**From:** Brian Banister [REDACTED]  
**Sent:** 05 December 2021 13:22  
**To:** Planning.Responses <Planning.Responses@arun.gov.uk>  
**Subject:** Re: Planning Consultation on: BR/247/21/PL

The views of the **Arun District Conservation Area Advisory Panel** are as follows:

**Application No:** BR/247/21/PL

**Description of Works:** Change of use from single dwelling (C3) to 6 No self-contained flats (C3), a 10-bedroom co-living housing unit (Sui Generis) & insertion of 3 No new front windows. This application affects the character & appearance of The Steyne, Bognor Conservation Area.

client	SPP
project	Ancient Mariner 59 West Street Bognor Regis PO21 1XB
project ref.	2553 Drawing No. 06
drawing title	Proposed elevations
drawn by	L.F.
date	June 21 scale 1:100@ A1
	www.bpmnet.co.uk info@bpmnet.co.uk

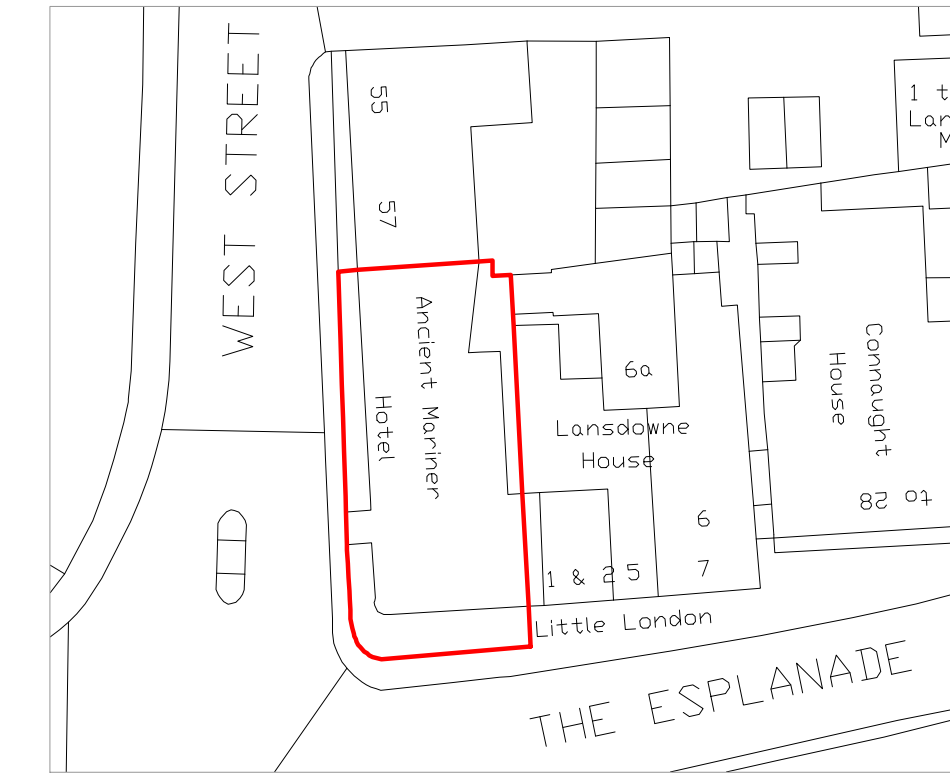
The south (seafront) elevation has a pleasing window to wall ratio and rhythm and the proposed new windows disrupt this to some extent. However, it would probably be difficult to justify a refusal of planning permission on this ground but it is essential that the materials, finishes and operating mechanisms of the new windows are appropriate given the historic context. The new windows also need to be recessed from the front wall to match the reveal depths of the existing window openings.

It is suggested that, if the Council is minded to grant planning permission, a condition is attached which requires the submission of precise details of the new windows including their materials, finishes, frame and glazing bar sizes, operating mechanisms and depths of reveals (all to be agreed by the Council's Conservation Officer).
